Header Schedule	Not Shown	SHOWN ON JOB SECTION - AND ALSO FORCED TO OFFICE
Type of Heating System	Not Shown	→ OIL FURNACE FORCED NOT WORK IN LABORATORY
Stairs		
Number of Stairways	4	
Material	2	
Exterior	2	
Treads and Rises (Section 314)	OK	
Width	OK	
Headroom	OK	
Handrails and Handrails (Section 315)	Shows 34" 36" - HANDRAILS WILL BE CUT 36"	
Smoke Detectors Location and type/interconnected	OK	
Plan Reviewer Signature

DATE: 1-28-04

RE: 226 Hope Road Lot # 15

Front Porch Detail

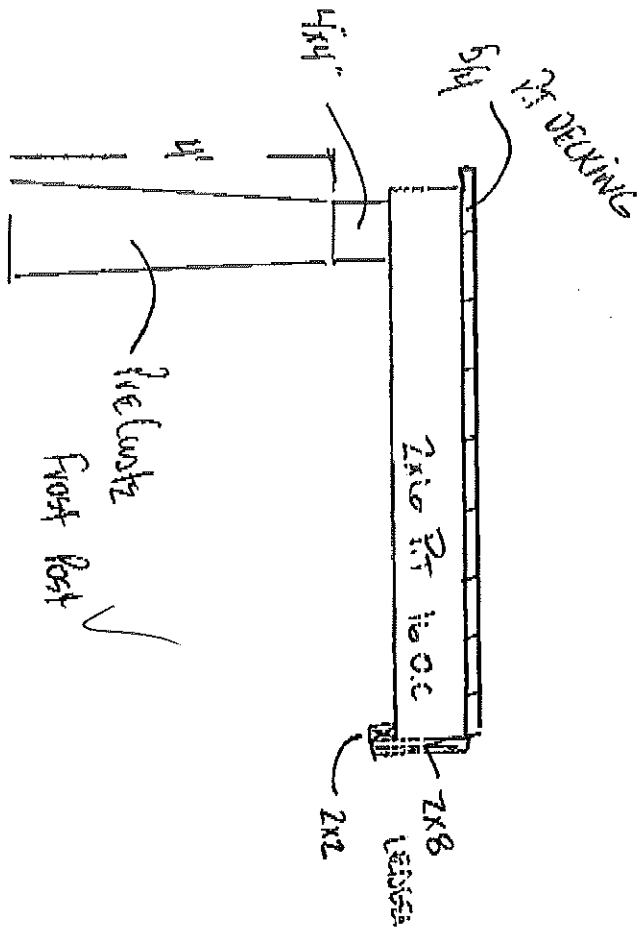
(9) Framing of deck + ~~FRONT PORCH~~ a front porch - FORCED TO OFFICE 1-28-04
